Response to Submissions Report

State Significant Development – SSD 17_8926

International Maarif Schools of Australia – Gallipoli Campus

2 Percy Street, Auburn

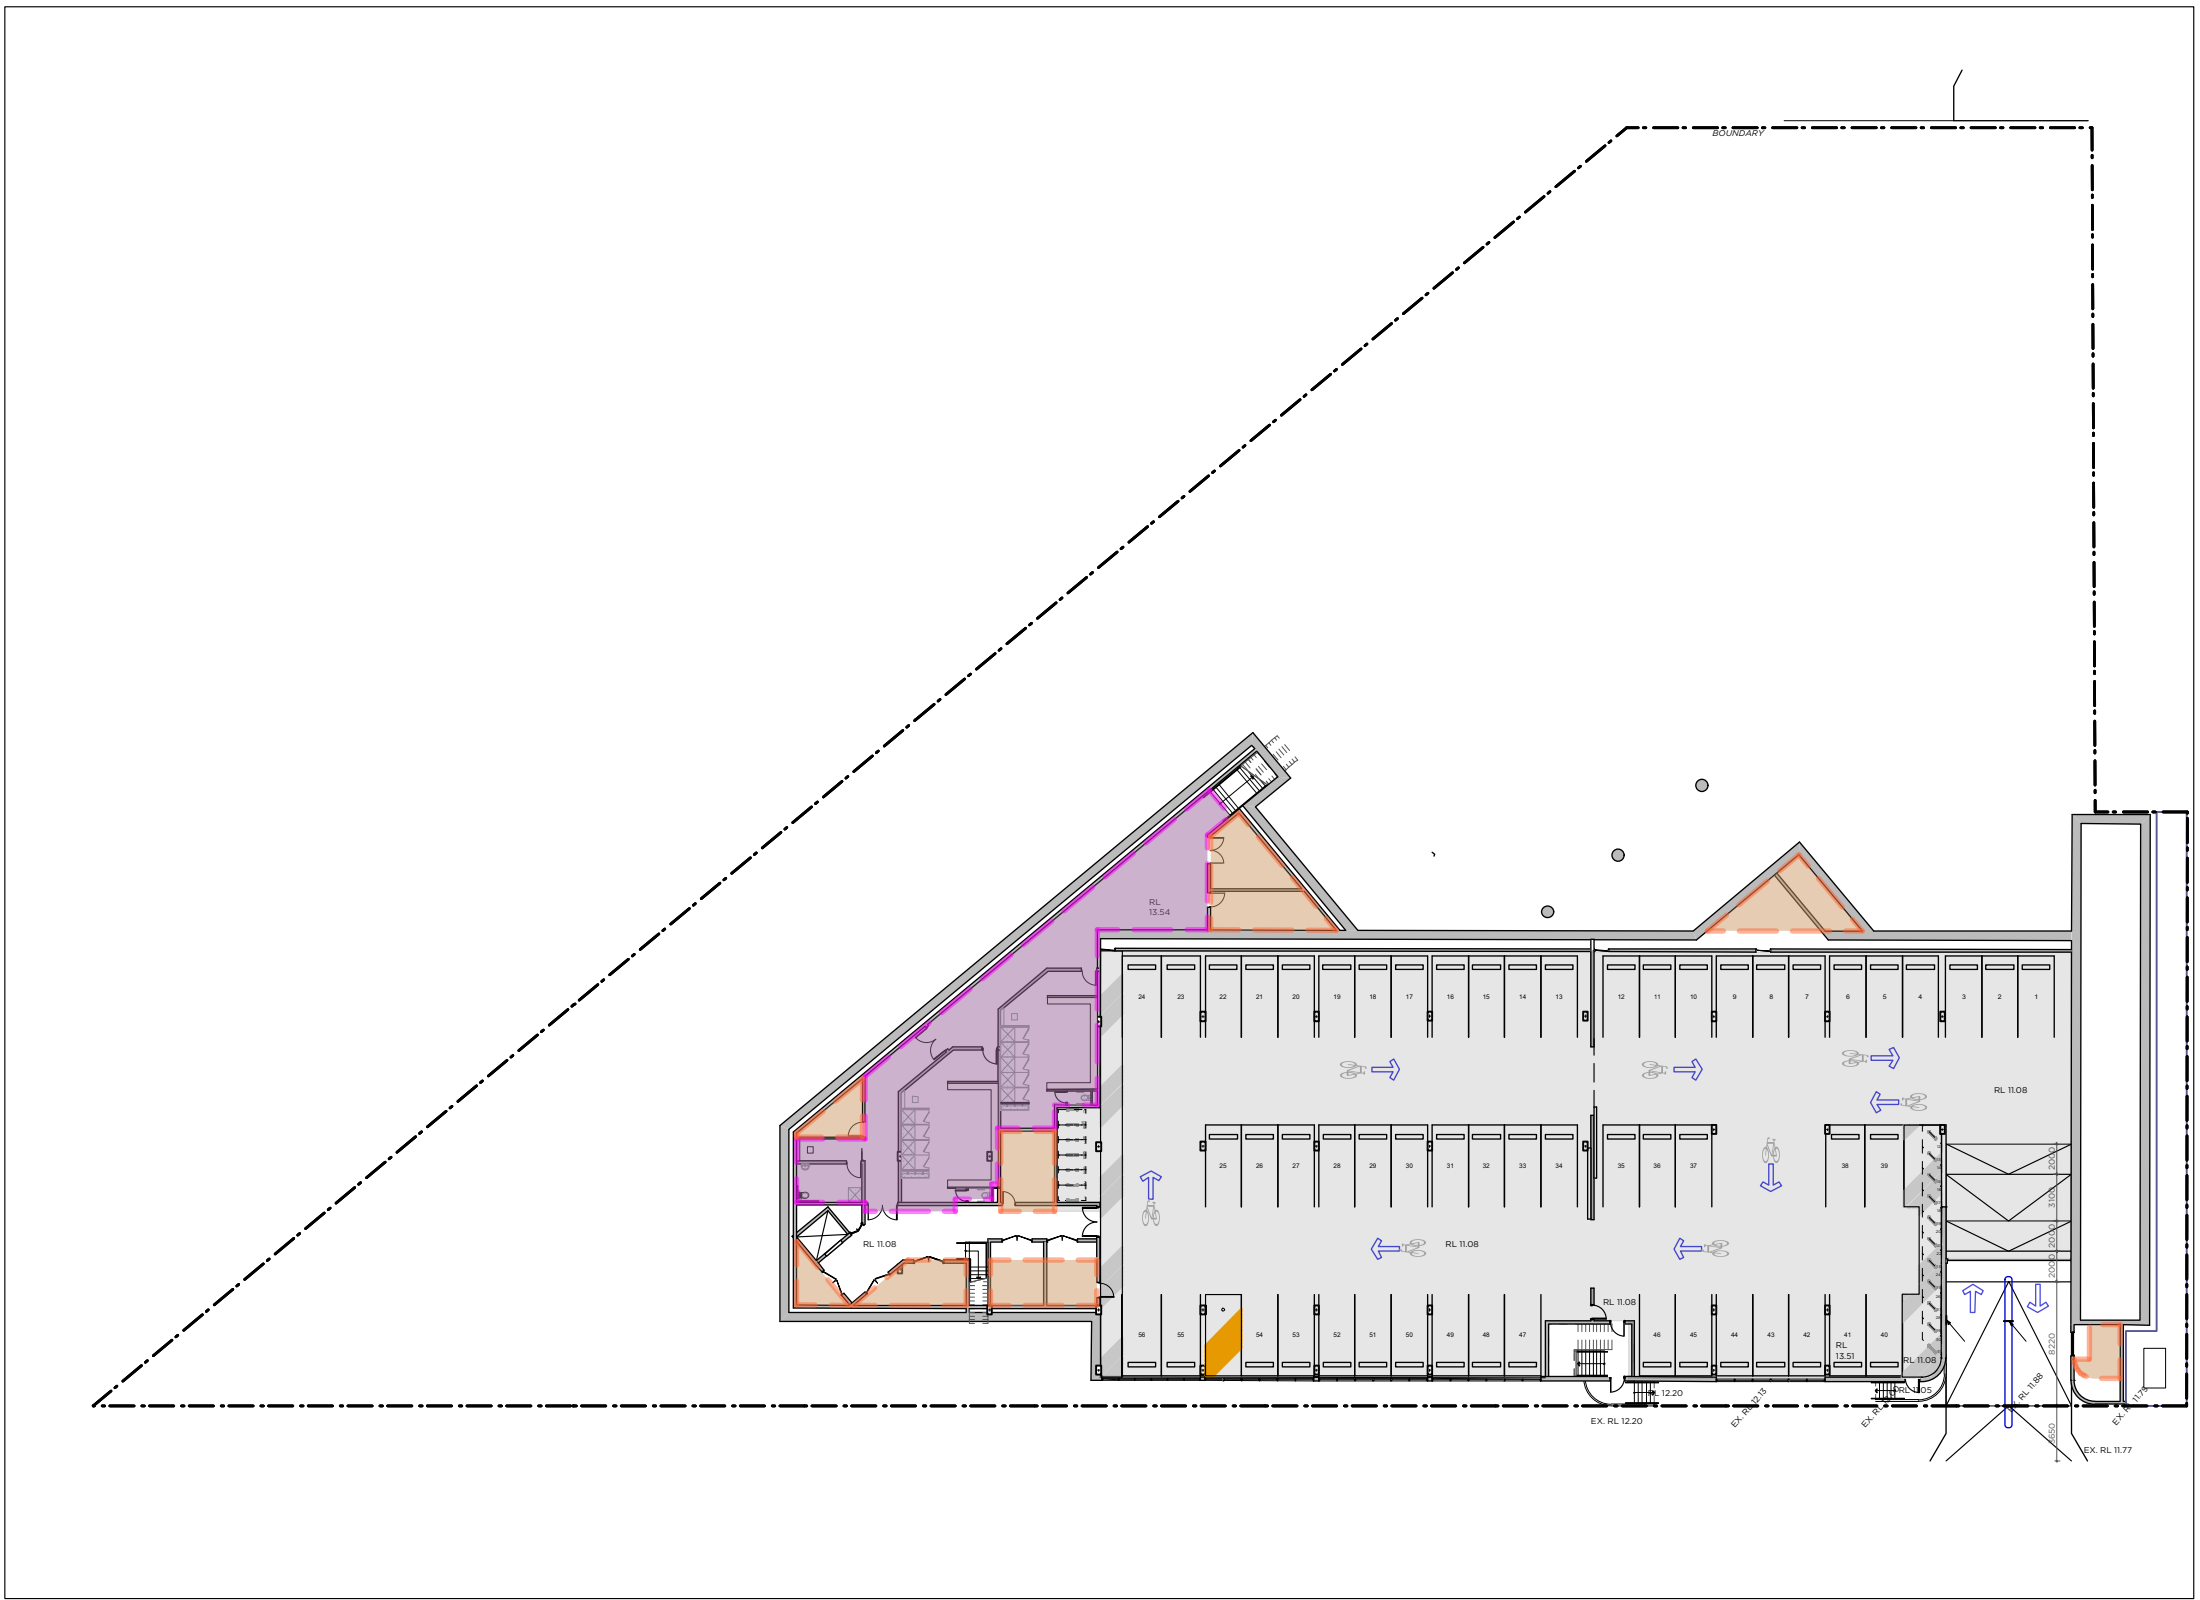
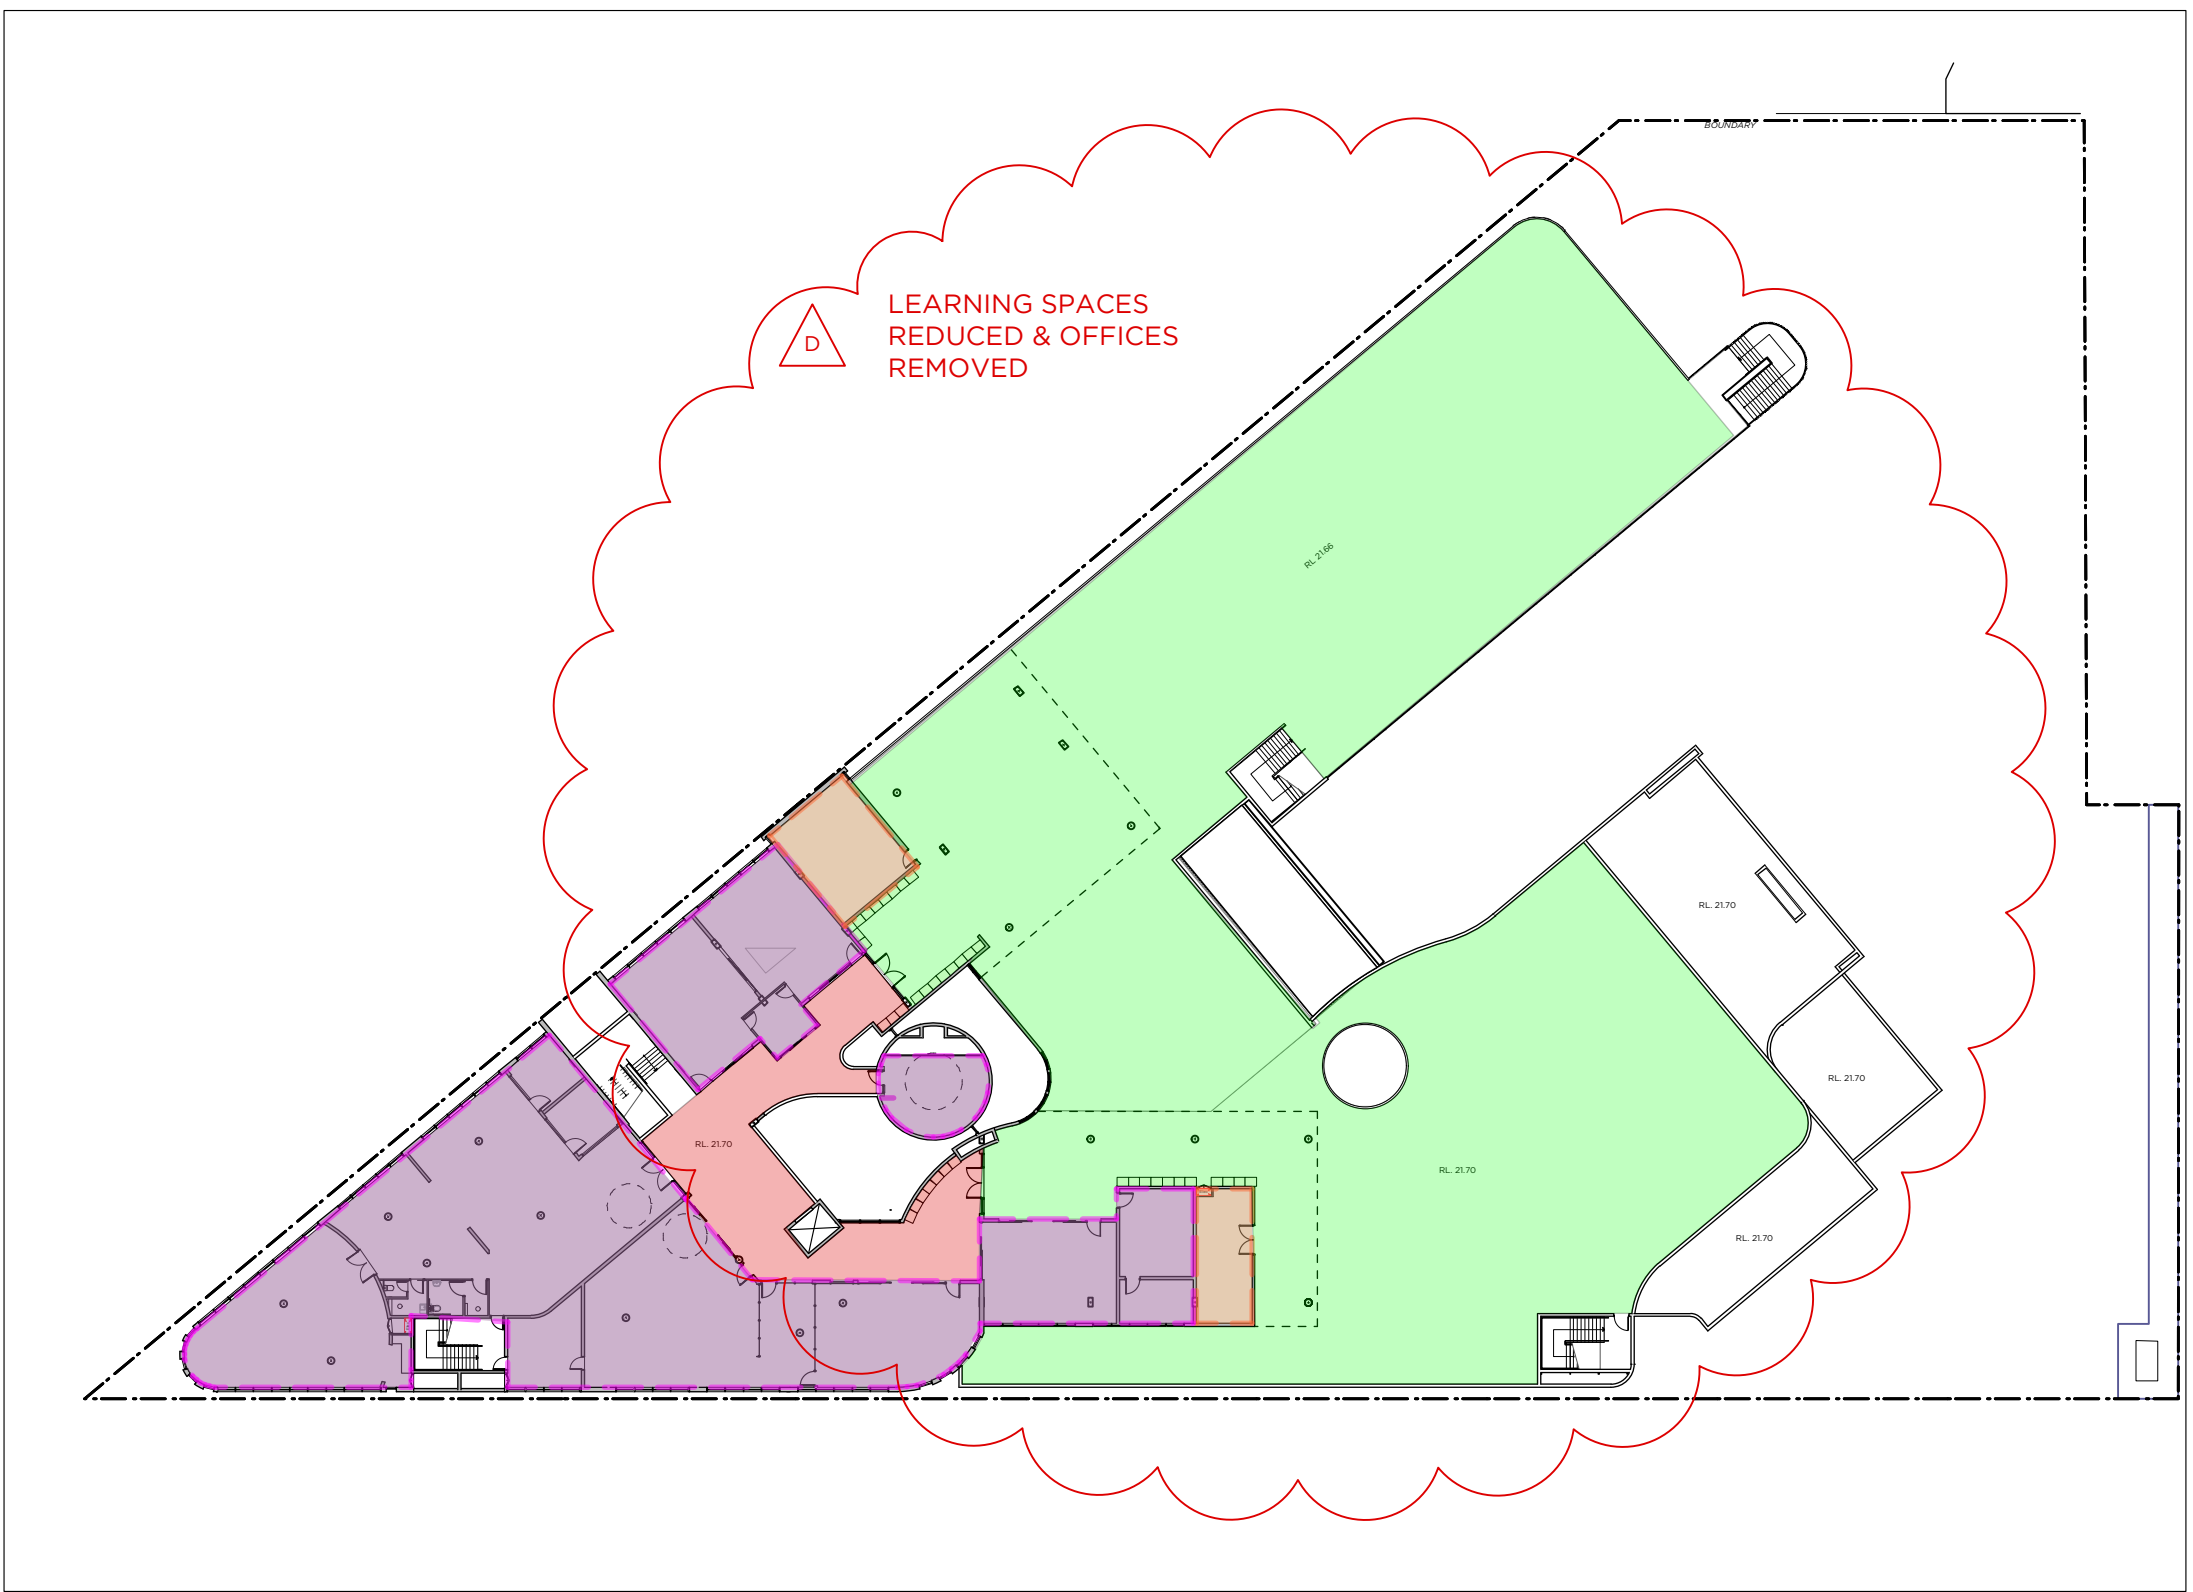
Issue	Response	Reference
Floor Space Ratio 7. The site currently has as FSR of 1:1. Council resolved to proceed with an FSR of 1:1, while the Gateway Determination required Council to consider an FSR of 1.2:1, and the proposal includes an FSR of 1.13:1. Table 2 of the EIS refers to a proposed FSR of 1.12:1 which is inconsistent with other areas of the EIS and the Planning Proposal. Additional information is required demonstrating what the proposed FSR is, and all documents should be updated to ensure consistency between the SSD and the Planning Proposal.	The architectural plans have been redesigned to remove some classroom space from Level 3 in order to reduce the GFA and in turn the FSR to 1:1 to be consistent with the Planning Proposal.	Appendix 1

- To fulfil this as part of the SSDA, PMDL has updated the Architectural Plans (**Appendix 1**) to reduce the gross floor area (GFA) of Level 3 by 1,141m² (see **Figure 1**). The amendments reduced classroom and associated circulation areas, and increased the balcony/outdoor learning area at the same level. PMDL and ATMF confirm that the changes do not warrant a reduction in the number of students and staff proposed, as the supply of facilities (including classrooms) can still support the intended population of 728 students and 58 FTE staff.
